**Consultation Response from KC,  
Highways Development Management****2025/93450 Fleece Farm, 15, Midway, South Crosland, Huddersfield, HD4 7DA****Prior notification for change of use of 2 agricultural buildings to 6 dwellings****Date Responded: 16/01/2026****Responding Officer: CNB****Responding Ref: K3-24/17**

This is a prior notification application for the change of use of 2 agricultural buildings to 6 dwellings within a farmyard with an existing access off Midway, a 30mph two-way single carriageway rural distributor road of approximately 7m width with a footway on the side of the application site and street lighting present.

BLOCK PLAN
1:500

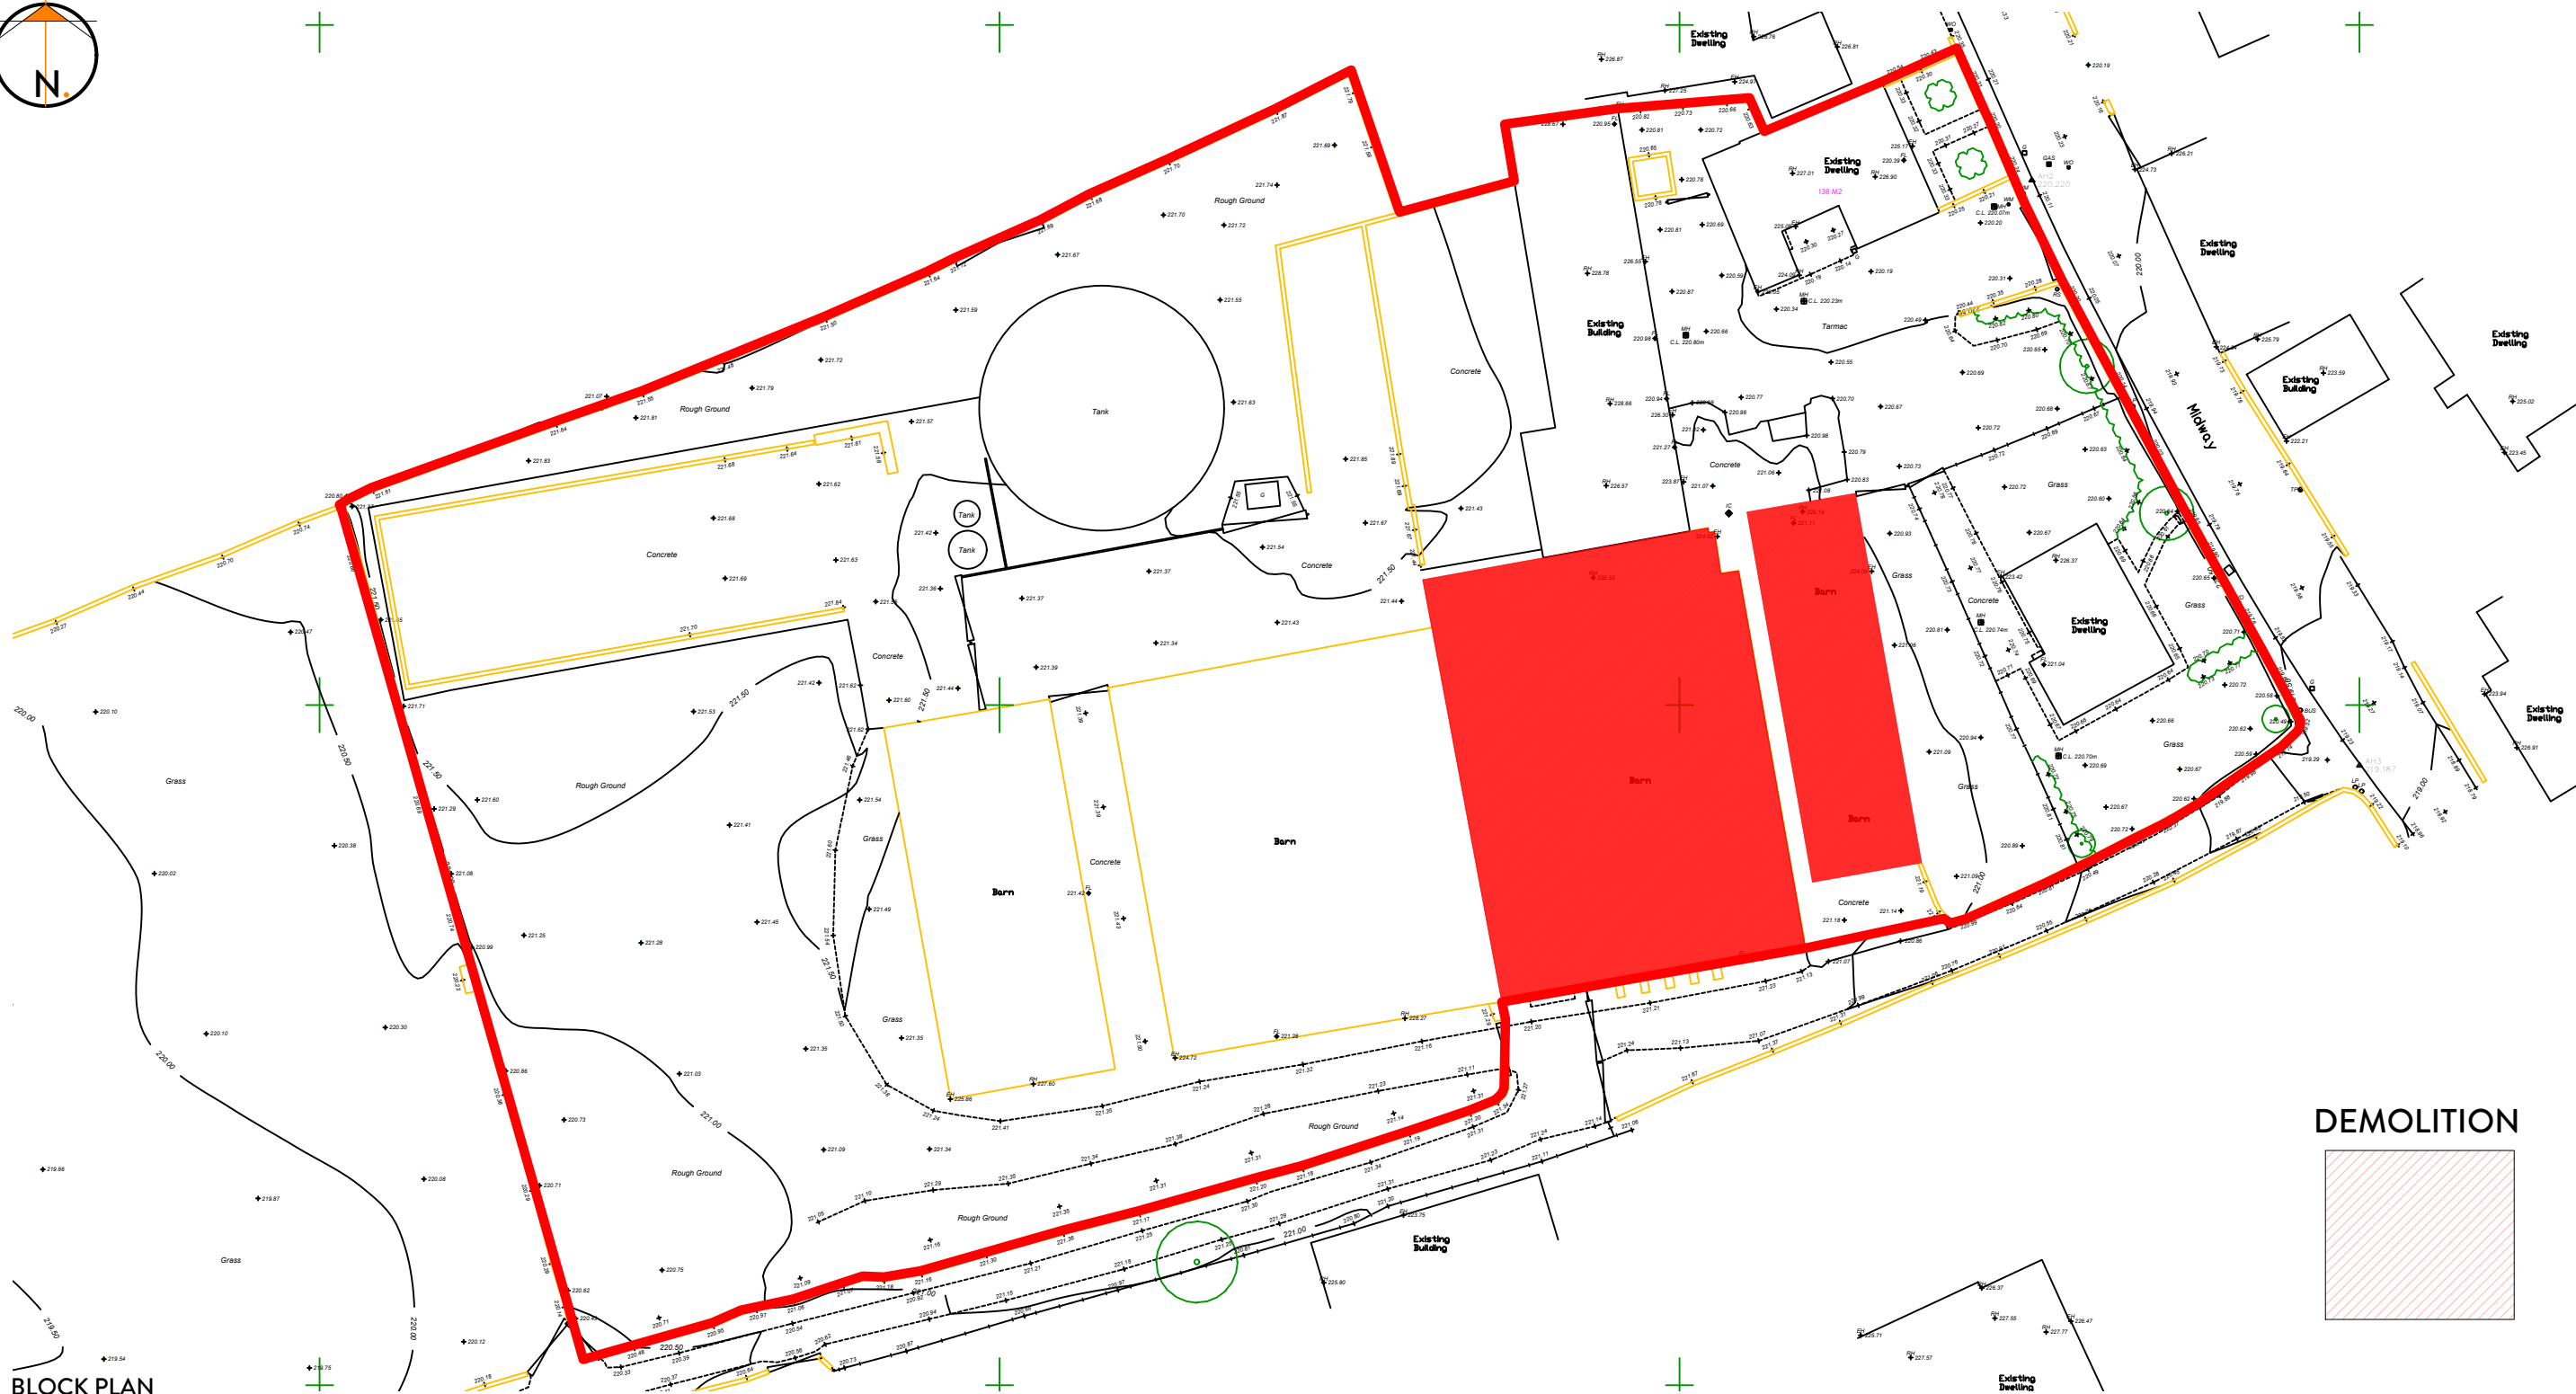
It is noted that the red-line boundary shown on the location plan Ref (EX) 002 does not connect with the adopted highway and as such makes the development site landlocked, however Drawings No (20) 002 Block Layout and (20) 003 Proposed Block Layout both show a larger red-line boundary that does connect to the adopted highway. Confirmation should be sought as to the full extent of the red-line boundary and if it connects to the adopted highway network.

The access is existing over a dropped kerb crossing and is currently used by farm traffic. It measures approximately 6m wide and this would be acceptable for two cars to pass. It is noted that the access is gated and we would like to see either the gates removed or set back 5m from the rear of the highway to allow a car to pull clear of the highway while waiting for the gates to be opened and this should be conditioned.

No visibility splays have been submitted for the access, as we would expect an intensification of use of the access with the development, we would like to see visibility splays of 2.4m x 43m clearly displayed on a drawing. These should be to the nearside kerb and cross nothing greater than 1m in height. If these full visibility splays cannot be achieved then we would be happy to see a reduction in the Y-length of the splay based on observed 85<sup>th</sup> percentile speed data obtained from an ATC on Midway and constructed to Manual for Streets calculations. This should be conditioned for highway safety reasons.

The proposals are for 6 two-bedroom dwellings and to follow local guidance this would require 2 off-street parking spaces per dwelling with one visitor parking space per 4 dwellings. Drawing No (20) 003 Proposed Block Layout shows that 12 resident spaces and two visitor spaces can be provided with suitable turning and manoeuvring space and this is acceptable.

As the development is accessed by a private driveway, the Kirklees Waste Strategy team have indicated that a refuse collection wagon would not access the site and so we would need to see details of a suitable bin collection presentation point located at the rear of the footway where any bins won't obstruct the access to the site or the footway or highway for highway safety reasons and this should be conditioned. Details of the requirements can be obtained from the Kirklees Cleansing department document and found here,

Prior to the development being brought into use, the sightlines of 2.4m x 43m along Midway shall be shown on a plan and presented to the local planning authority for written approval and afterward these visibility splays be cleared of all obstructions to visibility exceeding 1m in height and these shall be retained free of any such obstruction throughout the lifetime of the development.

Notwithstanding the provisions of the Town and Country Planning (General Permitted Development) Order 1995, (or any order revoking and re-enacting that order) any gates or barriers for or over a vehicular access or egress shall be set back 5m from the back of the footway on Midway and shall be hung as to only open inwards. So long as such gates or barriers are in position they shall be retained to only open inwards.
